From: Sadie Maddock [REDACTED]
Sent: 24 February 2022 [REDACTED]
To: Planning.Response [REDACTED]
Subject: Fwd: Request for further information A/27/22/HH

4 Weavers Hill, Angmering, Littlehampton, BN16 4BP

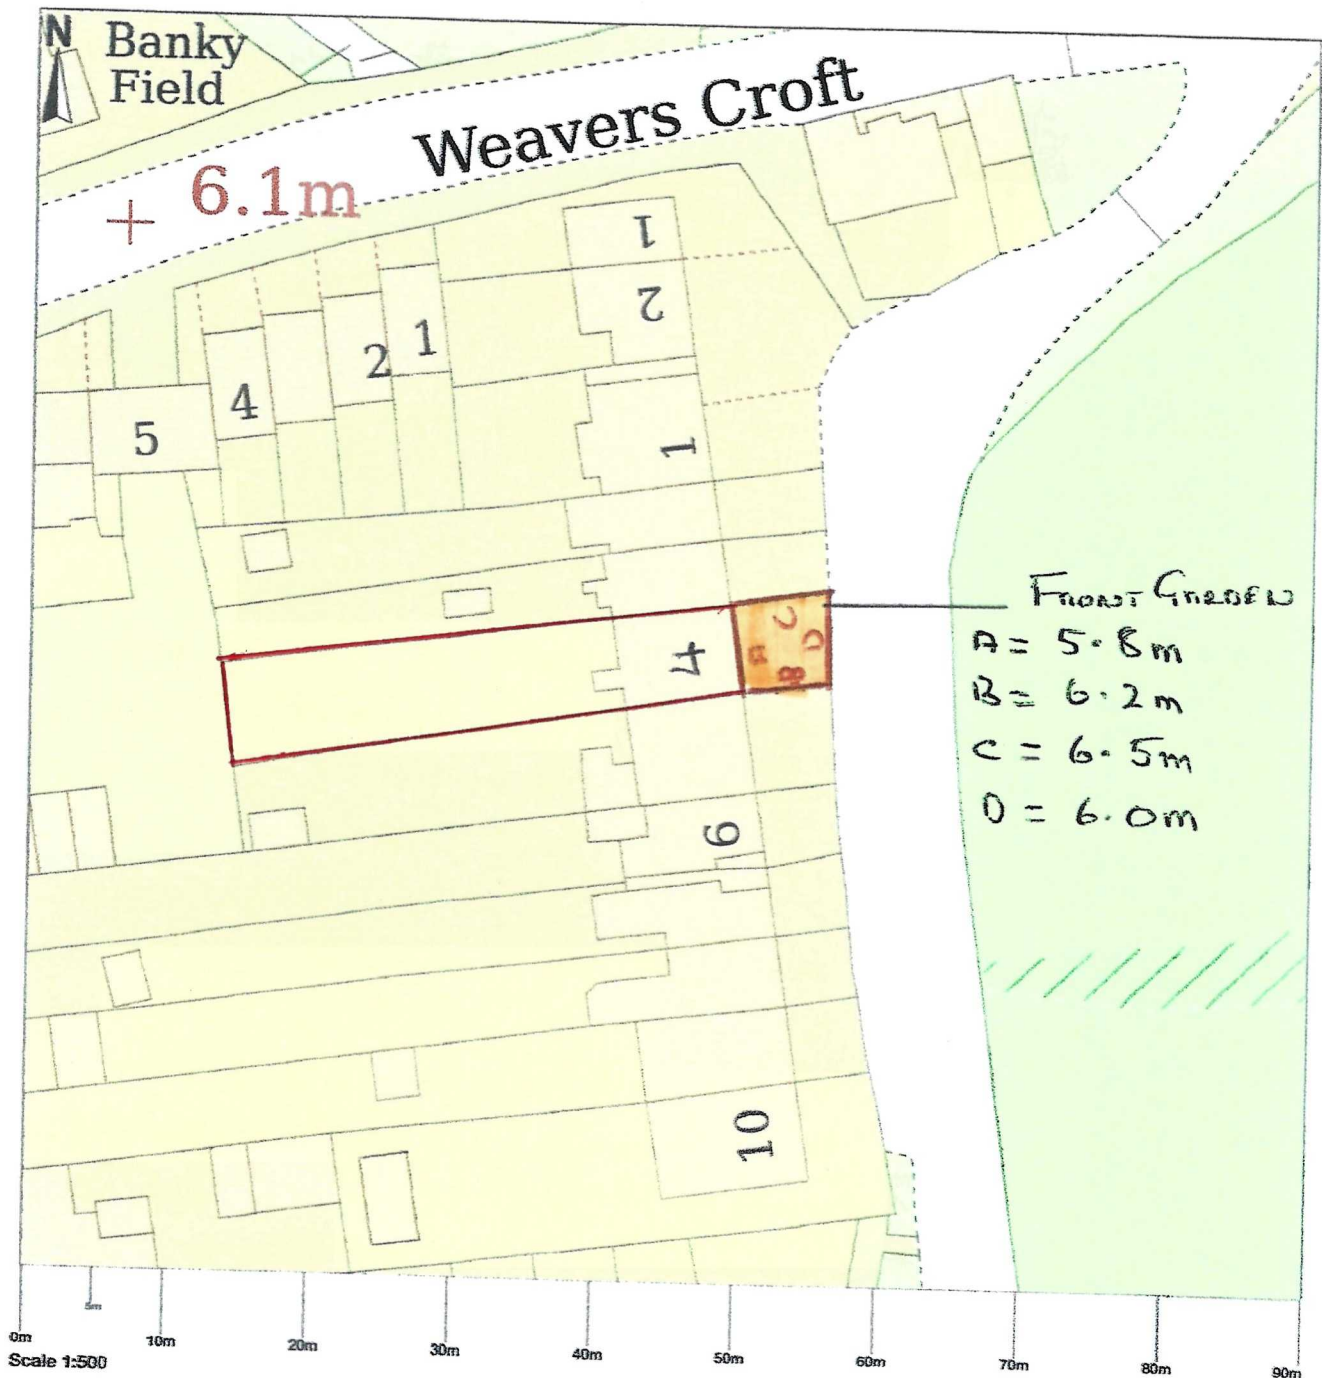
Thank you for providing the block plan with dimensions. However, we also require annotations to show the proposed works. Please amend.

I am a little confused by what additional detail you are looking for but on this copy I have outlined the property boundary in red and the front garden which is the proposed hard standing is highlighted in orange with the dimensions annotated.
